COLORADO
Department of Transportation
Region 2
Traffic & Safety - Access Permits

July 24, 2024

RE: PPR2422 - UDON RV Storage Plot Plan Review

FIGURE 17
 UDON REZONE
 EL PASO COUNTY, COLORADO
 2026 RECOMMENDED GEOMETRY &
 CONTROL – PHASE 1

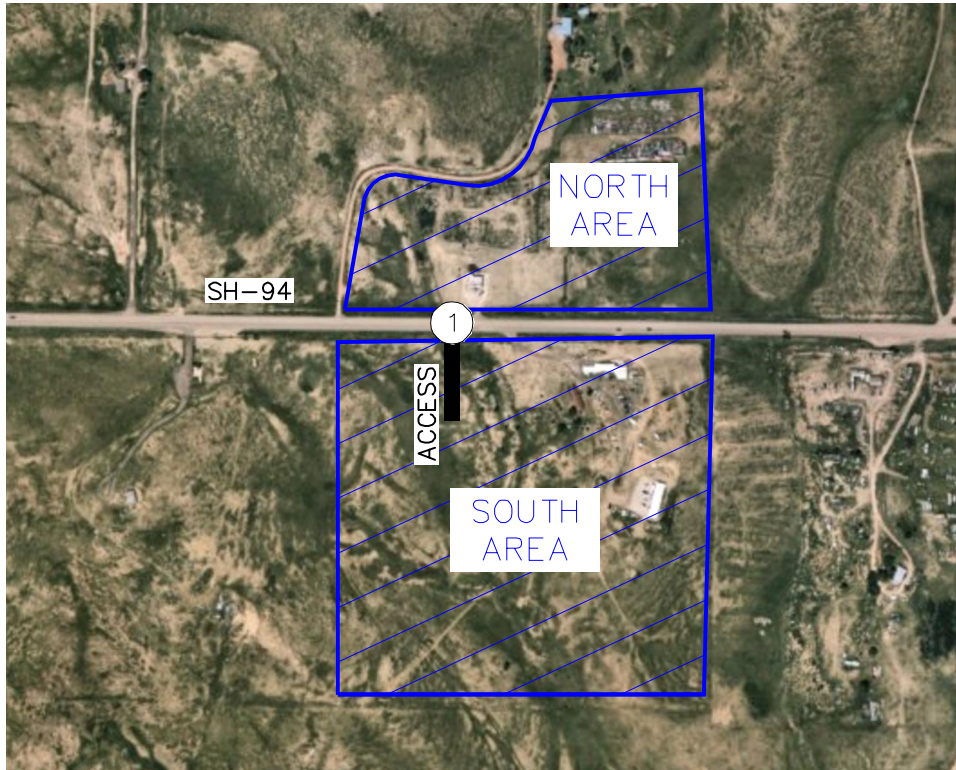
- The access will initially be a T-intersection with only the south area developing in Phase 1.
- A CDOT Access Permit Application with instructions as well as a copy of the State Highway Access Code (SHAC) can be downloaded at: www.codot.gov/accesspermits . Email your applications to michelle.regalado@state.co.us.

FIGURE 19
 UDON REZONE
 EL PASO COUNTY, COLORADO
 2028 RECOMMENDED GEOMETRY &
 CONTROL – HIGHEST USE

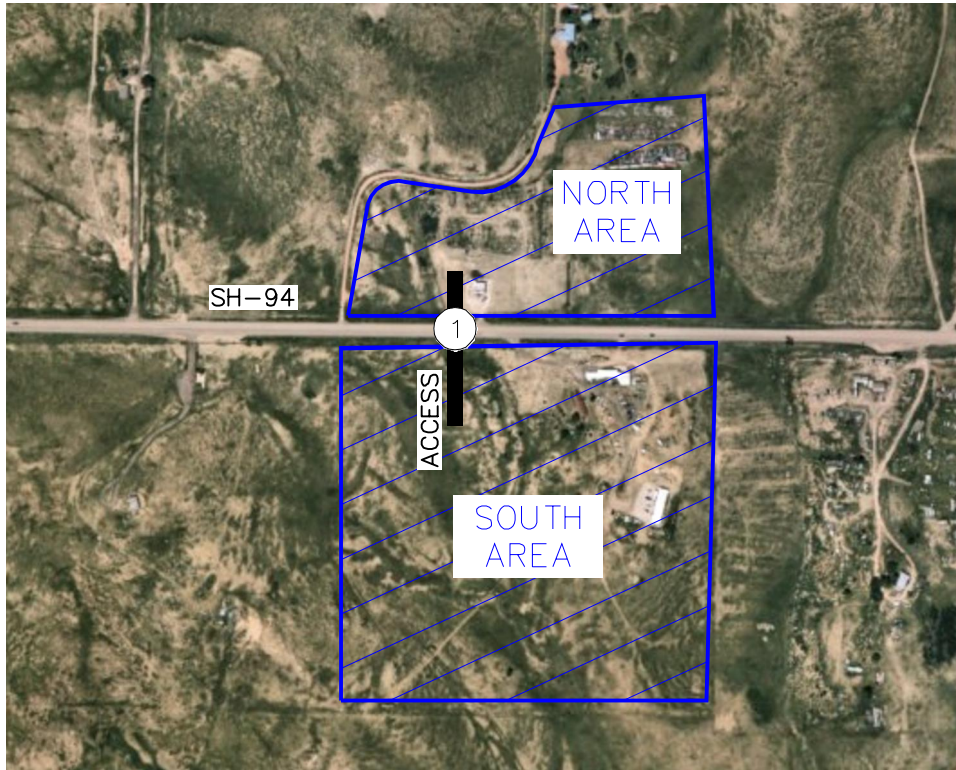
- Given that this application is for a rezone to commercial use, CDOT Traffic anticipates that at full build out the access will warrant auxiliary lanes and an intersection control analysis. CDOT Traffic agrees that no improvements for the storage units are warranted.
- As development continues, additional review from CDOT is required.
